APPLICATION FOR: 30255/APP/2020/4275

279 SWAKELEYS ROAD ICKENHAM

Item No.	Report of the Head of Planning, Transportation and Regeneration	
Address	279 SWAKELEYS ROAD ICKENHAM	
Development:	Erection of a two storey building with habitable roofspace to consist of 6 x 2-bed and 1 x 3-bed self-contained flats with parking and amenity space, involving demolition of existing dwelling.	
LBH Ref Nos:	30255/APP/2020/4275	
Drawing Nos:	101 102 120 SR/1000/CP 118 107 Design and Access Statement 114 115 116 119 Arboricultural Survey. 100 Drawing Register CIL Form

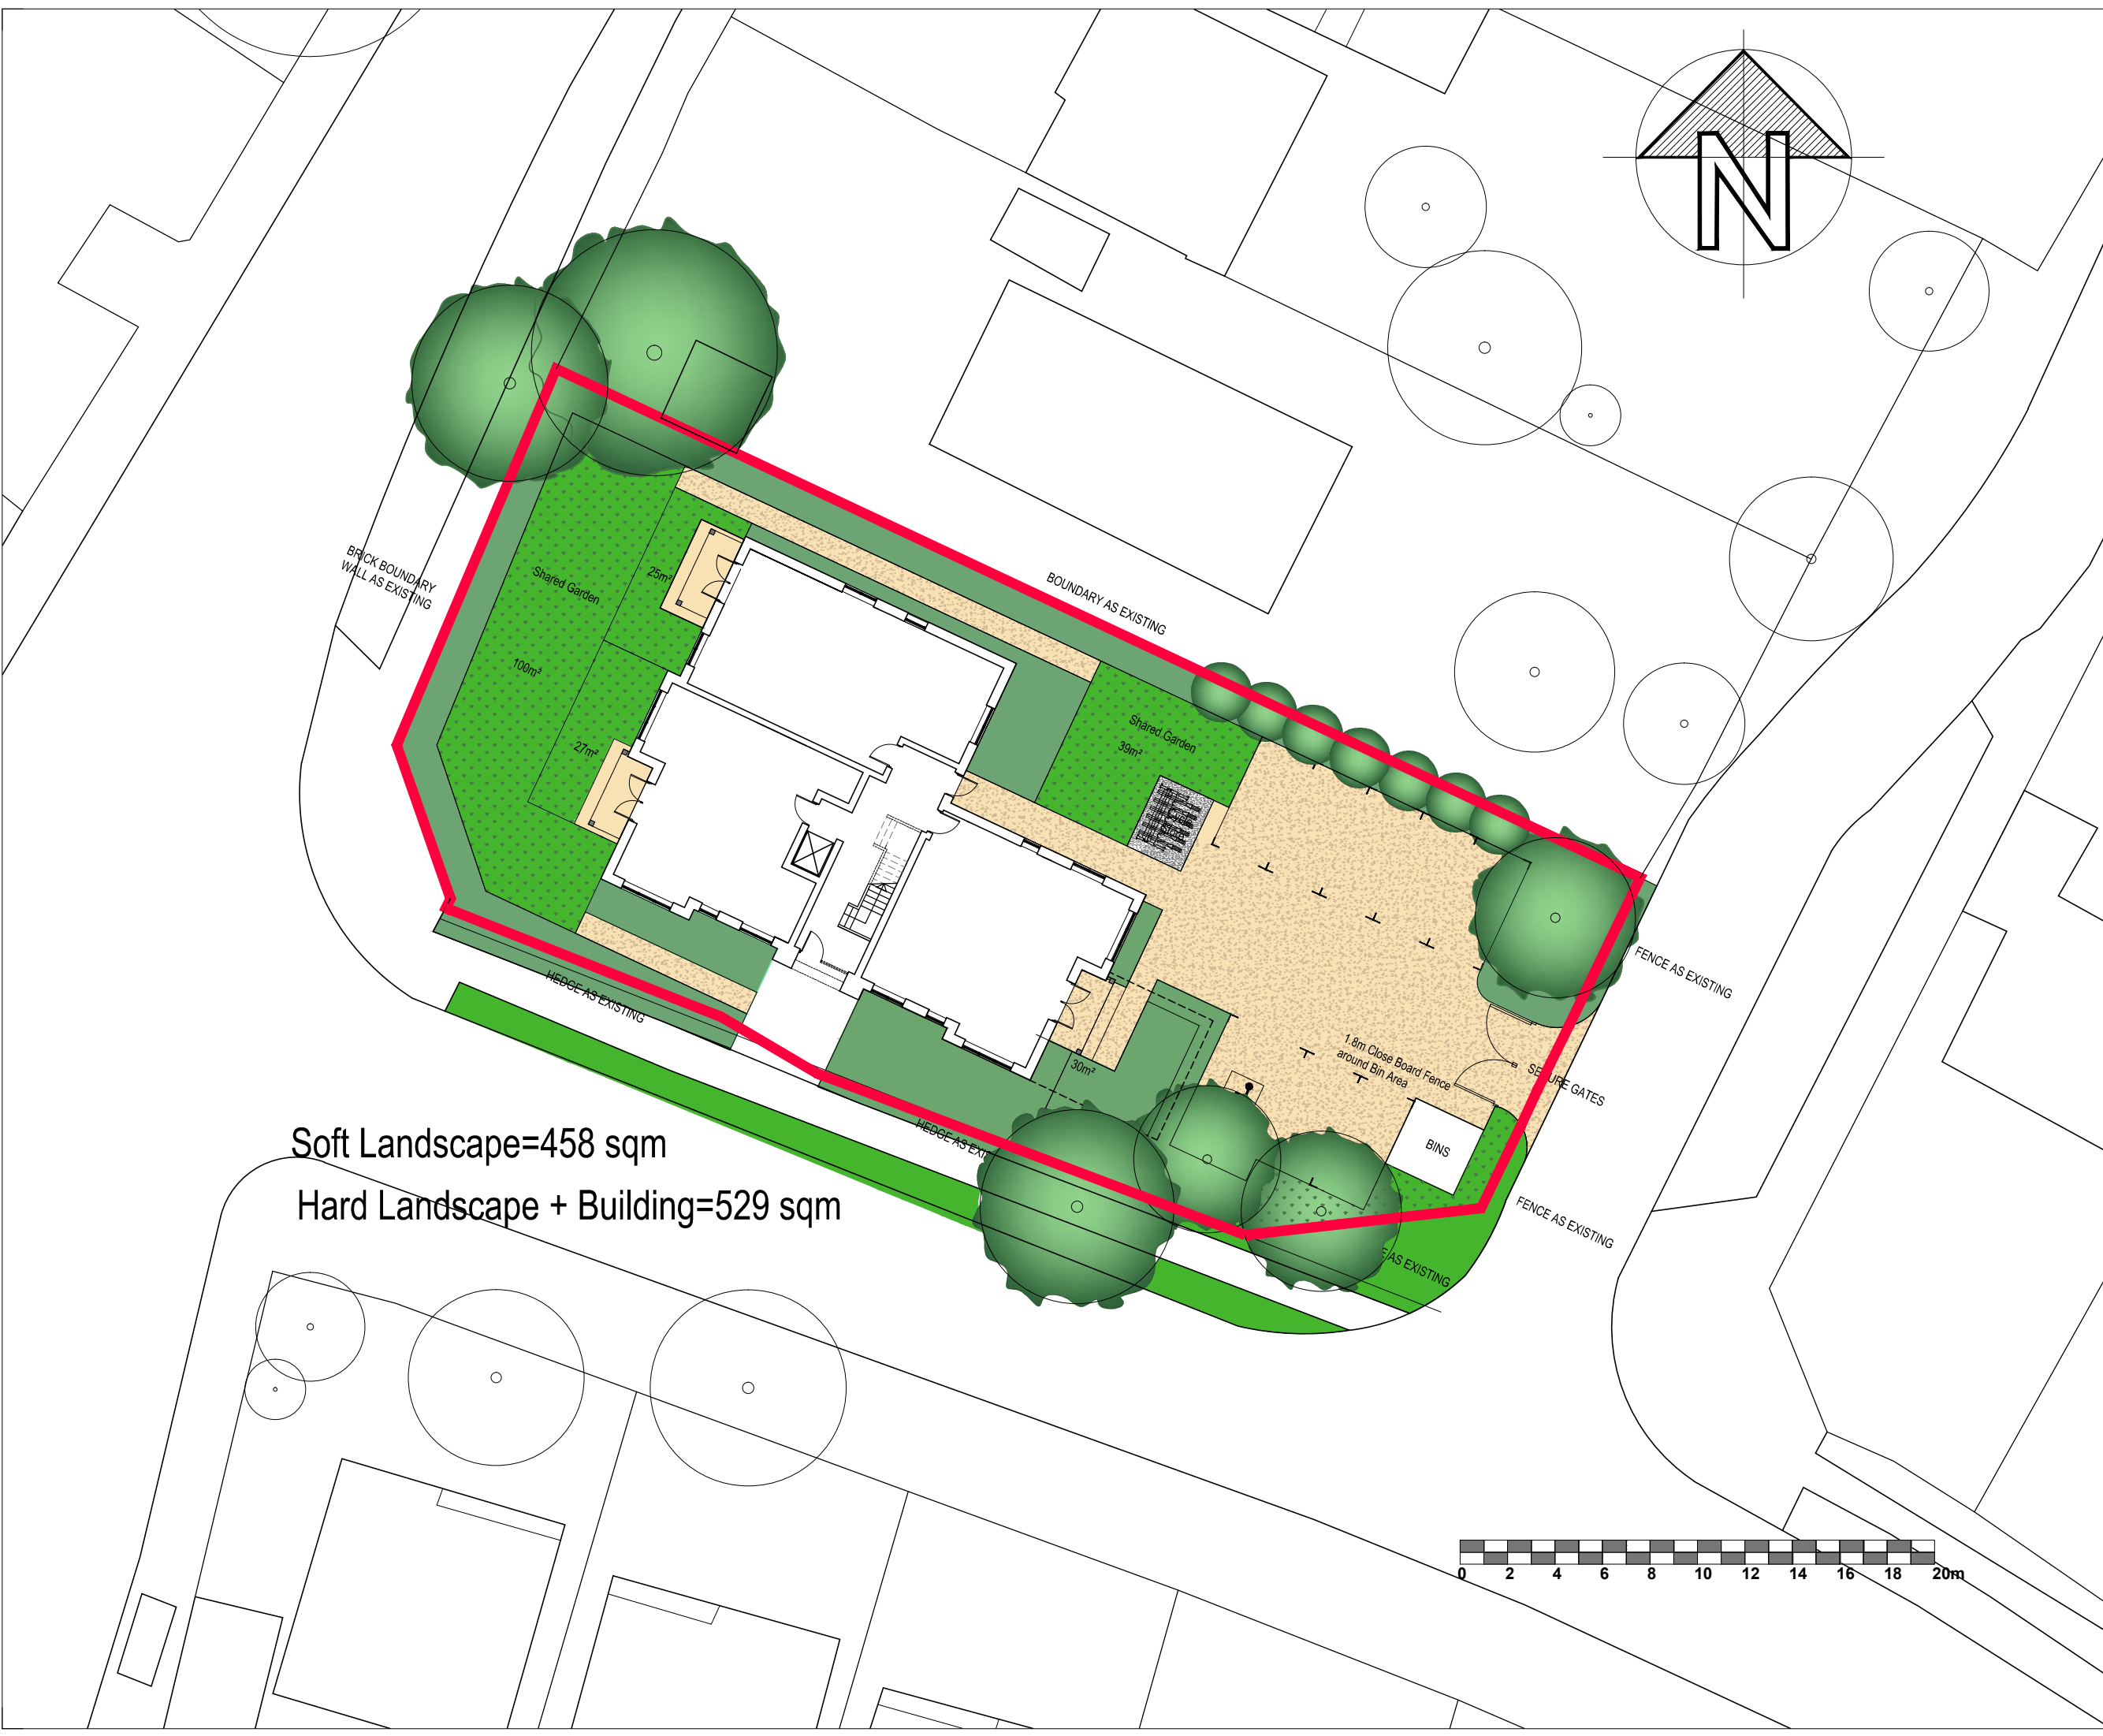
The proposed car parking and functional requirement for hard surfacing, together with the footprint of the building, is disproportionate to the residual areas of usable soft landscaped space, with limited space for boundary planting and replacement trees. Such limited landscaped areas when combined with the need to provide external cycle and bin stores would be considered prejudicial to the character and appearance of the streetscene and wider area. As such the proposal fails to comply with Policies DMHB 11 and DMHB 18 of the Hillingdon Local Plan: Part Two - Development Management Policies (2020).

The development also removes nearly all soft landscaping to the rear resulting in a hard landscape dominated by cars highly visible to the rear from Silver Birch Close.

The existing rear garden area would be used to provide car parking spaces therefore there is no good quality, useable private outdoor communal element of amenity space.

The proposed car parking and functional requirement for hard surfacing, together with the footprint of the building, is disproportionate to the residual areas of usable soft landscaped space, albeit there will be space for boundary planting and replacement trees.

GROUND FLOOR PLAN

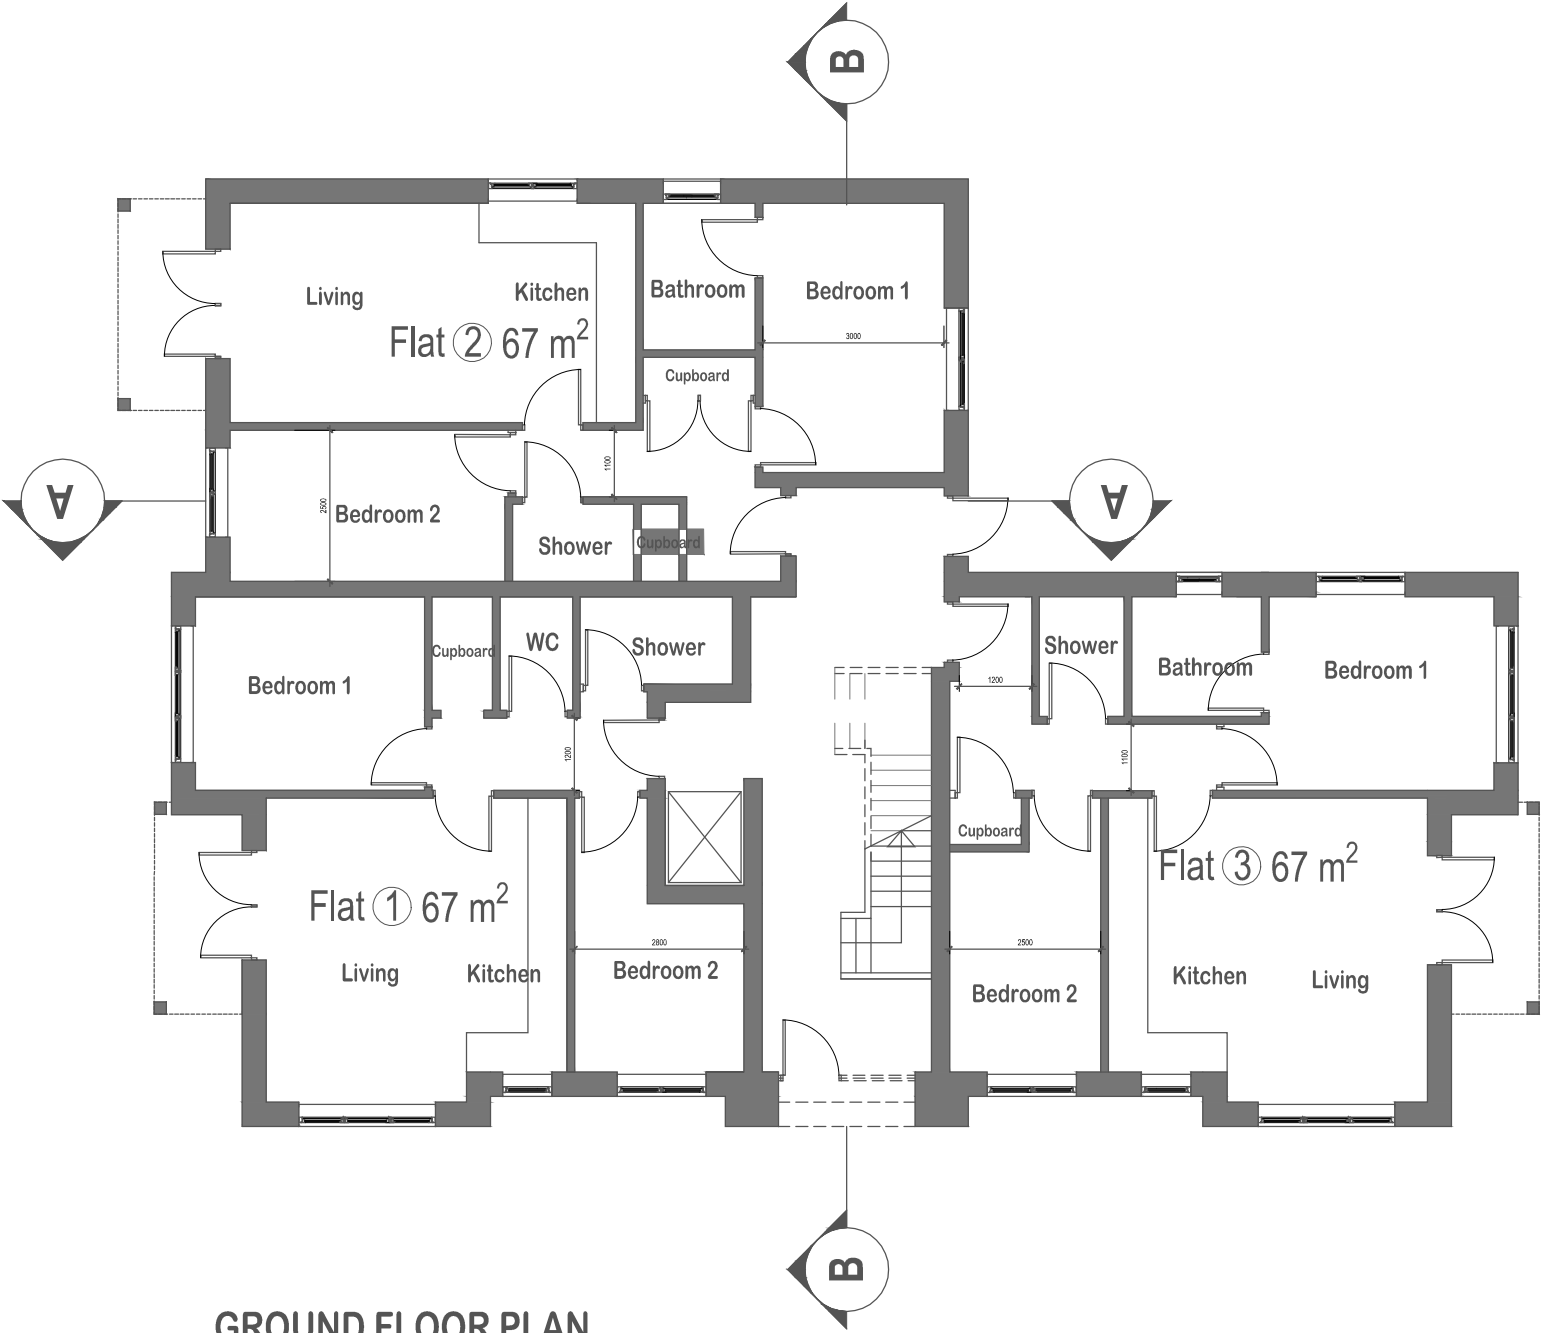
The flats on the ground and first floor have access to balconies of approximately 6 sqm and the top floor flat would have two balconies providing an approximate total of 7.5 sqm

which falls considerable short of the minimum amenity space requirements.
